8. **Project# 1010014**
14DRB-70096 MINOR - PRELIMINARY/
FINAL PLAT APPROVAL

PROFESSIONAL SURVEYING LLC agent(s) for VIOLA A SINGLE REQUEST request(s) the above action(s) for all or a portion of Lot(s) 23 & 24, Block(s) 8, **GLENWOOD HILLS** Unit(s) 2, zoned R-1, located on WESTRIDGE PL AND CEDARBROOK AVE containing approximately .5288 acre(s). (F-23) **THE PRELIMINARY/FINAL PLAT WAS APPROVED WITH FINAL SIGN OFF DELEGATED TO PLANNING FOR UTILITY COMPANIES SIGNATURES AND AGIS DXF.**

DRB Comments

RE: Lots 23 & 24, Block 8, Glenwood Hills Unit 2

SKETCH PLAT
 PLAT OF LOTS 23-A AND 24-A, BLOCK 8
 GLENWOOD HILLS UNIT 1
 ALBUQUERQUE, BERNALILLO COUNTY, NEW MEXICO
 MARCH 2014

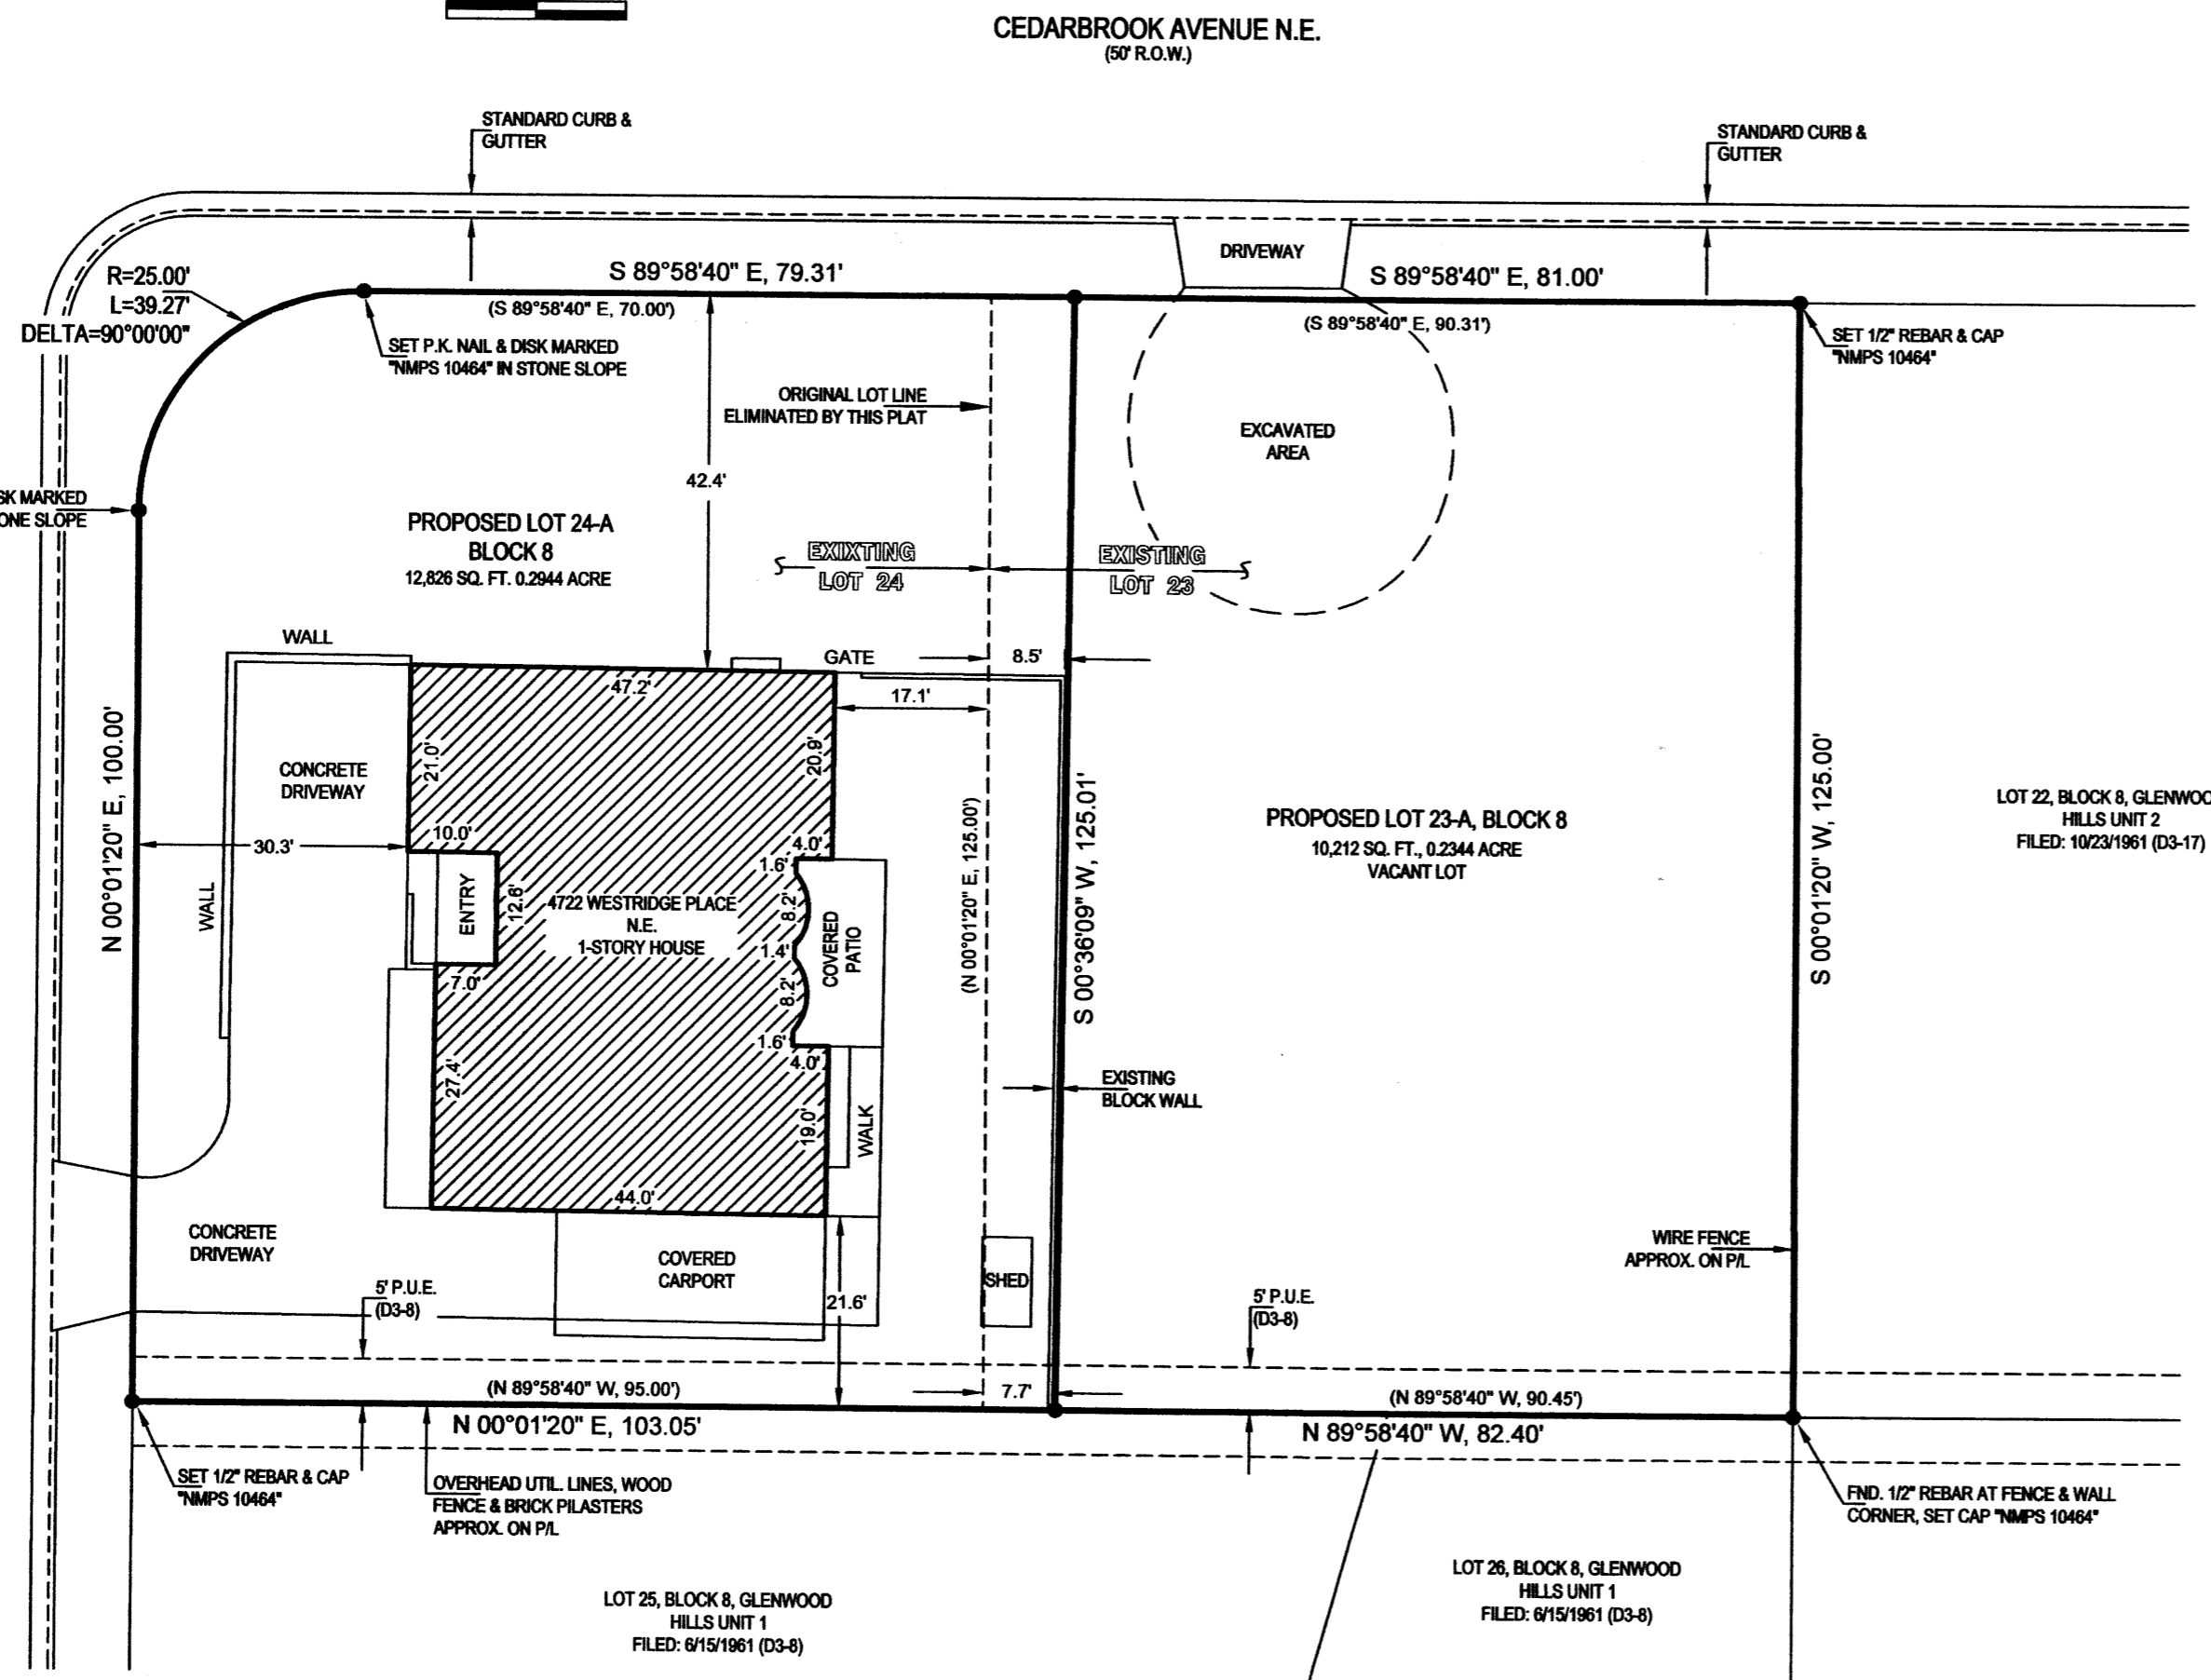
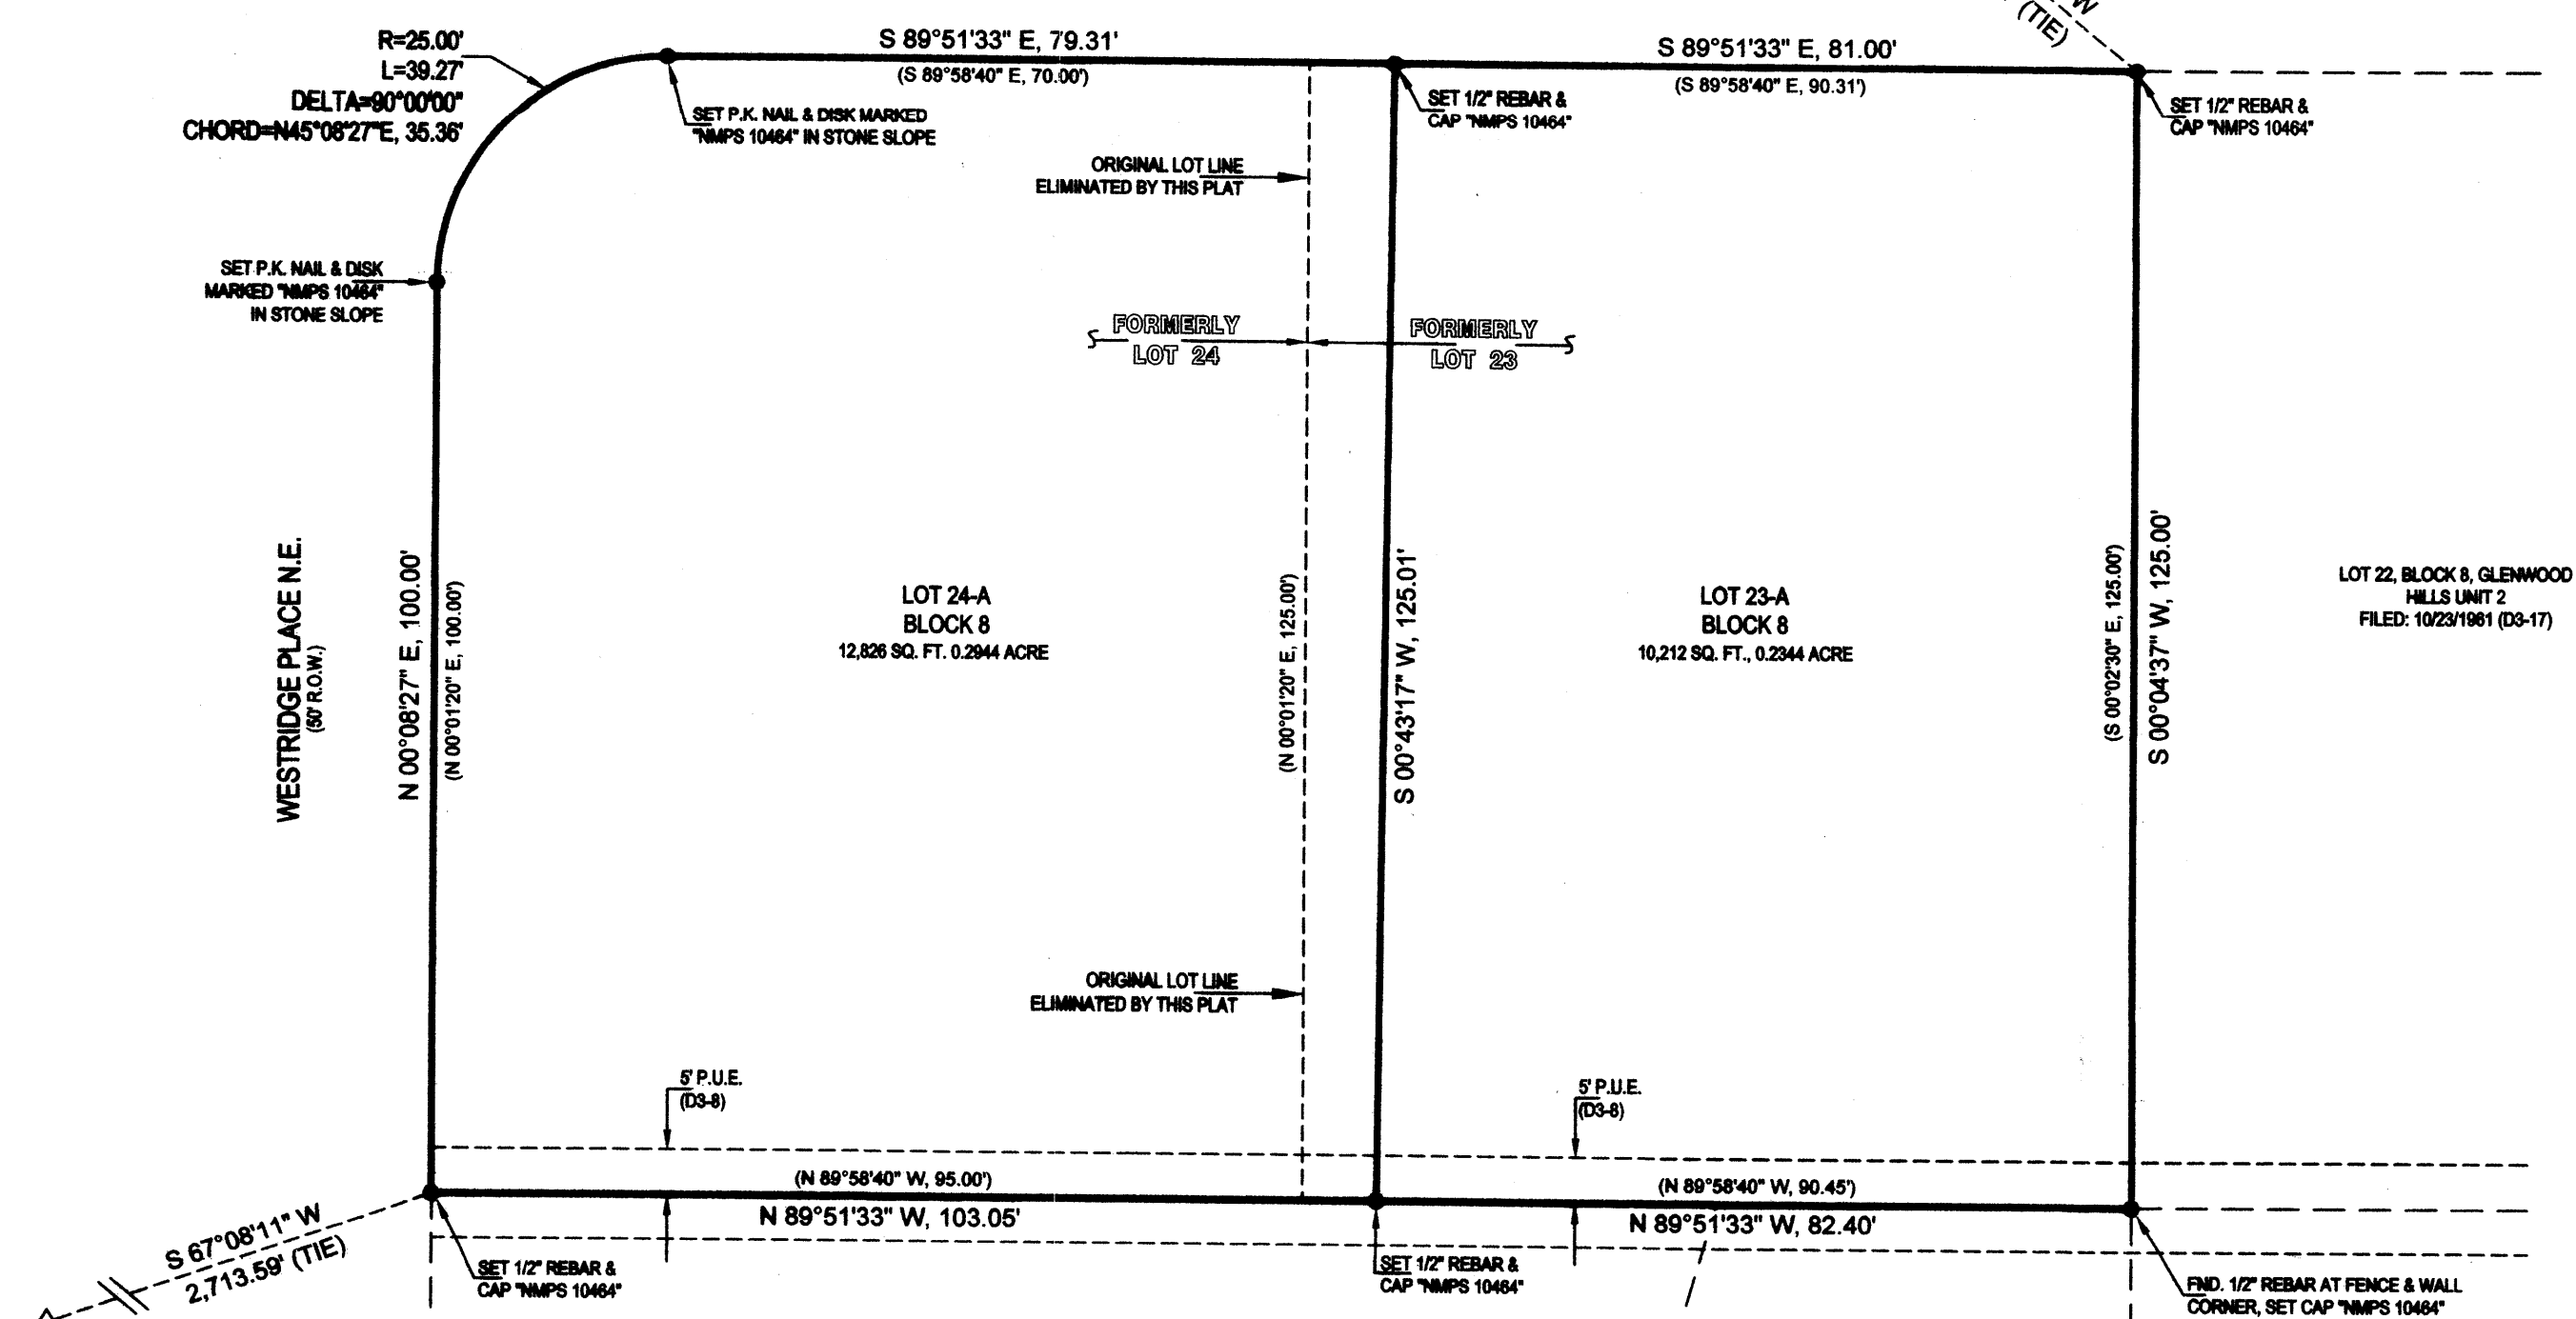
Please remove ZONING note from Subdivision data for Final Plat.

Done
4/14
